3 December 2018

Your Ref. ENF/397/16

**Alleged unauthorised development: Land Aldingbourne Farm
Shop/Nyton Stables PO203NH and Comments on Planning Application
AL/107/18/PL**

PROJECT: NYTON STABLES, ALDINGBOURNE, WEST SUSSEX	DATE: AUGUST 2018
DRAWING: LANDSCAPE PROPOSALS	SCALE: 1:1250 @ A3
	DRAWN: CHECKED:
	DRAWING NO: 18307-2-101

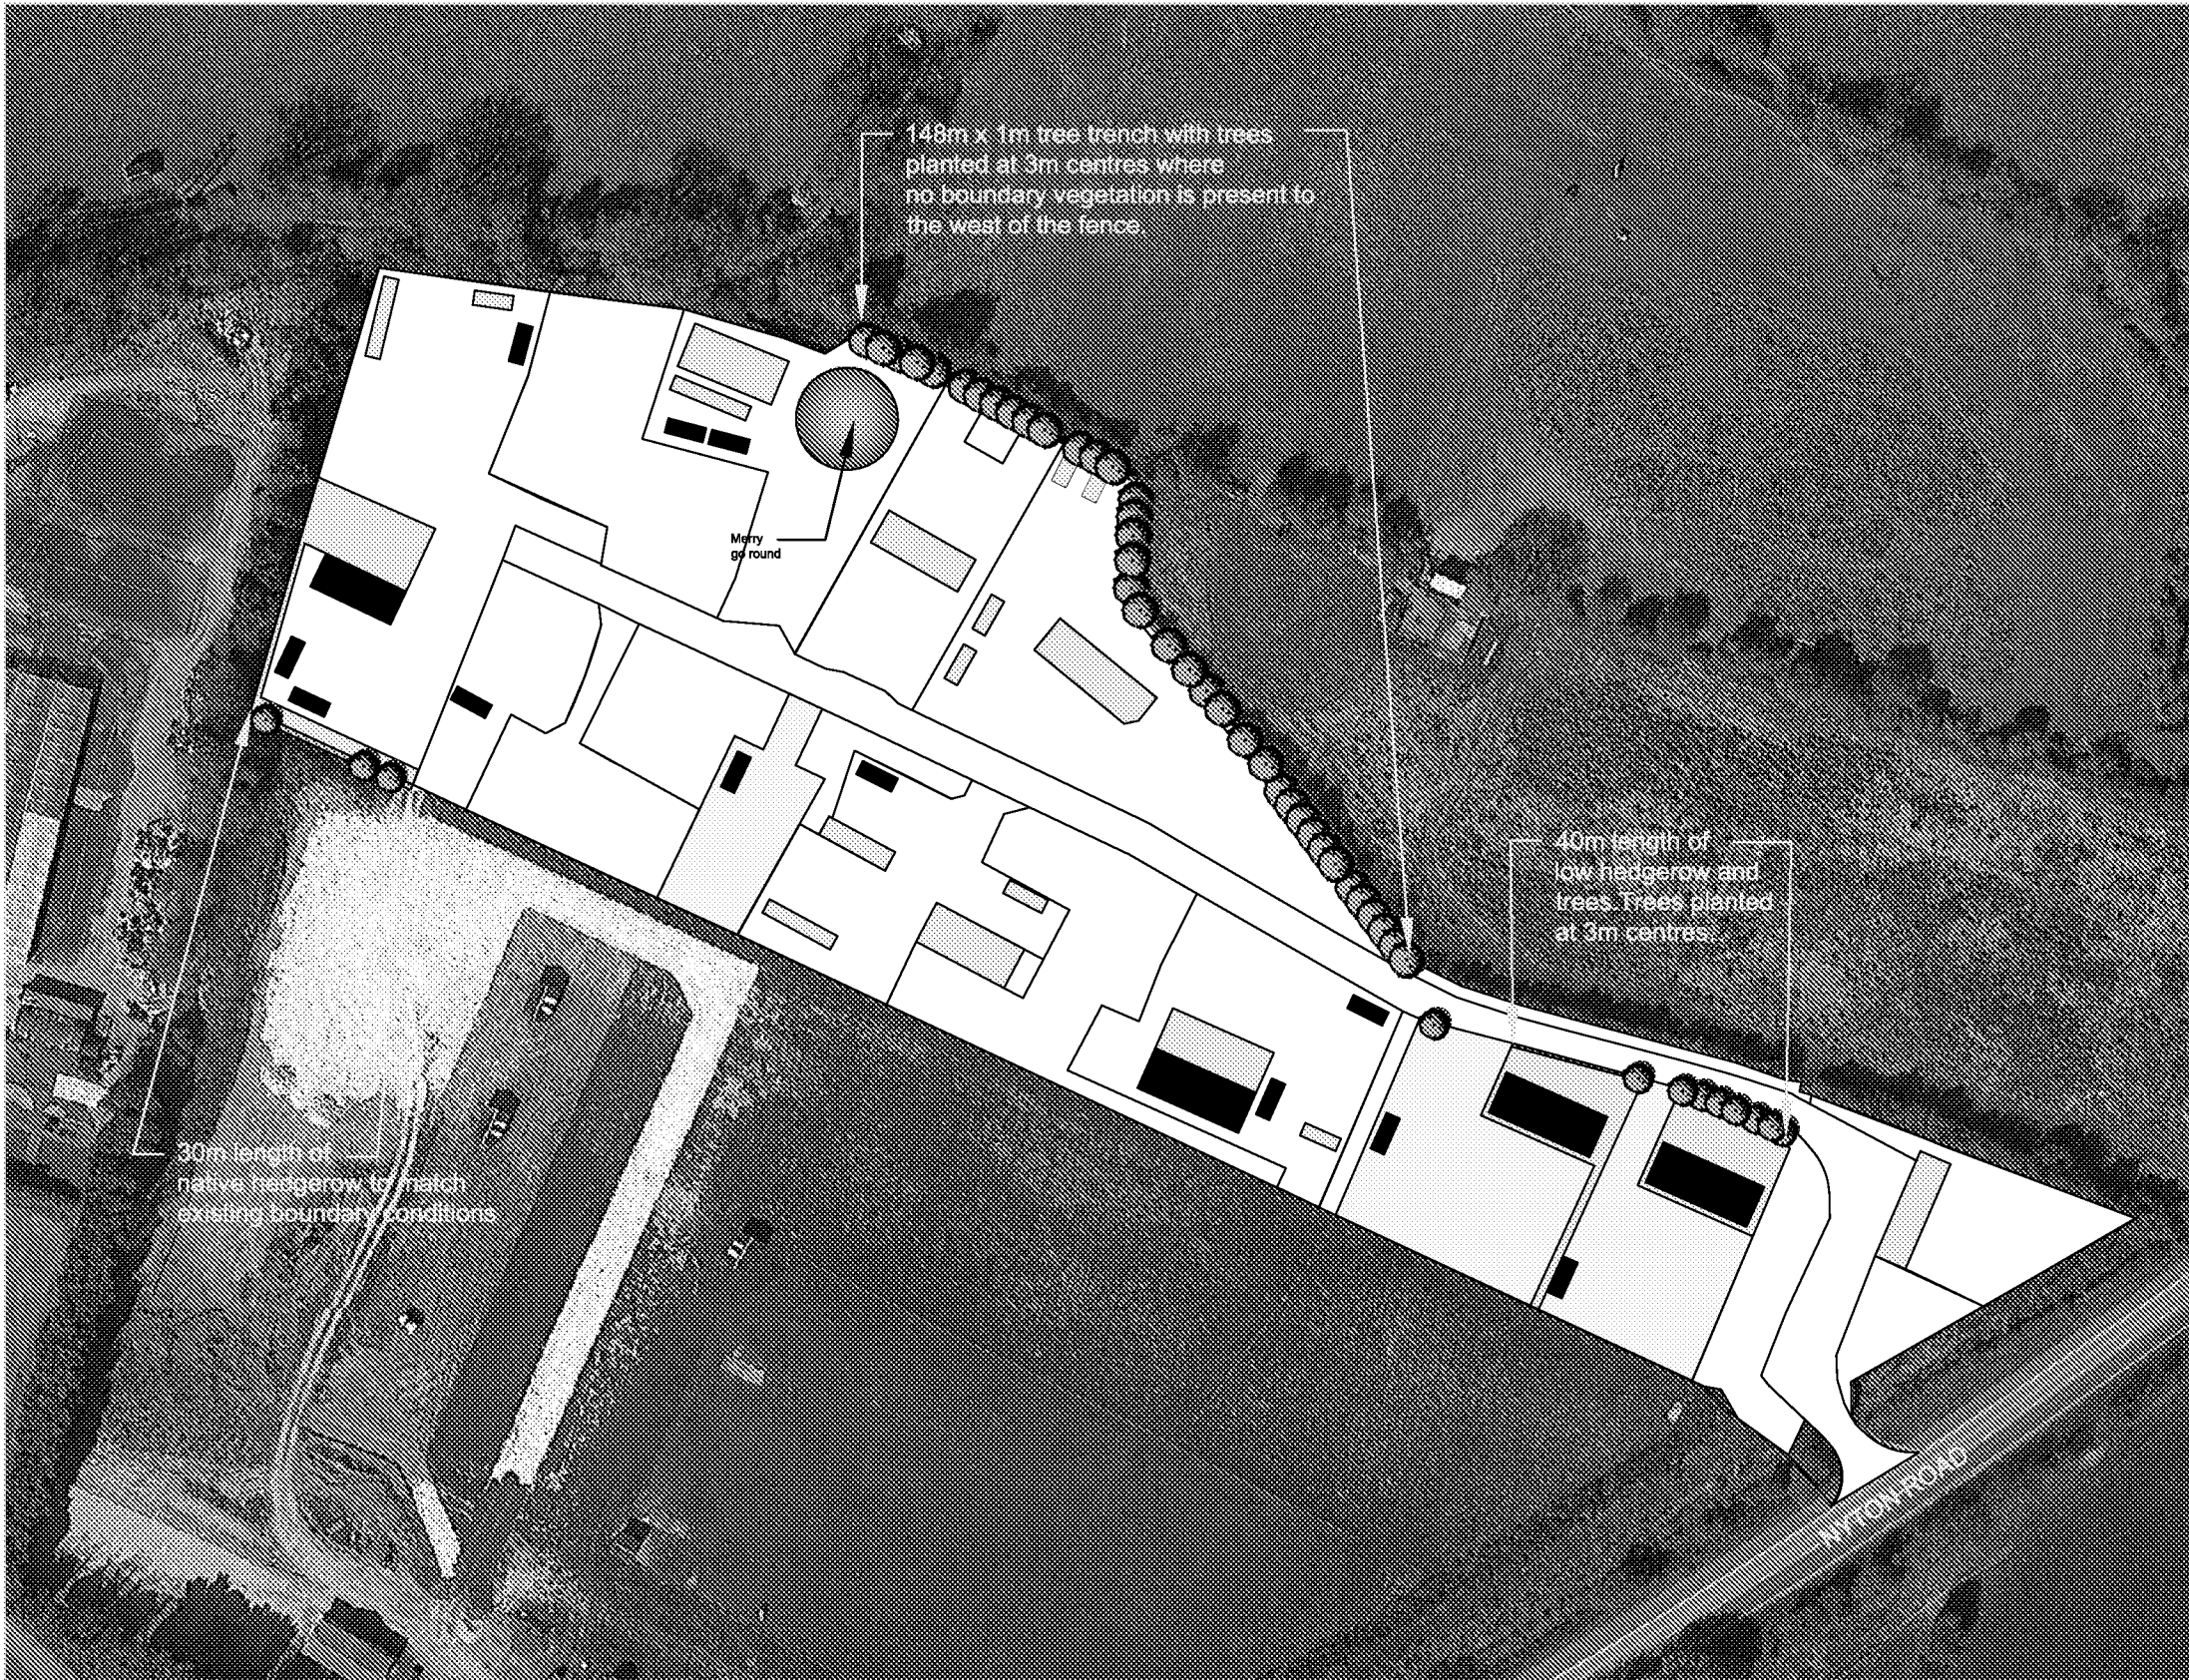
Though we welcome the promised trees, which would certainly improve things long term, but it does not seriously address the all round visual problem we experience. We also believe that single row planting is not sufficient to obscure this development even long term. We cannot be expected to wait another 10 years to gain the required cover.

Considering that the impact of these "white blocks" is going to increase considerably in the near future further supports the serious need for a bund, as well as landscaping. This has been discussed with ADC, and we believe is what is required in order to protect us.

We have also asked for a **10ft panel** fence to replace the inadequate 6ft panel fence, and at a higher level along this boundary area, to give us protection in the absence of any mature landscaping at present.

1. A **landscaped bund** similar to that already established along Nyton Road.
2. A **10ft panel fence** or similar at a higher level to give us some immediate cover, especially essential at the southern end.
3. If PP for these mobile homes to remain in their present position is to be granted, then we request that the **sidelights on walls** mentioned by us on numerous occasions, including our objections to AL/23/17/DOC be **removed**. They are unnecessary and extremely intrusive. If these mobile homes had been sited as per PP, these lights and their reflective effect would not be directed at us.
4. For **Lighting** to be **implemented** and **used only IF** and when **absolutely necessary**, and with **consideration**.

8.45 What is proposed for the western boundary will not be "fit for purpose".
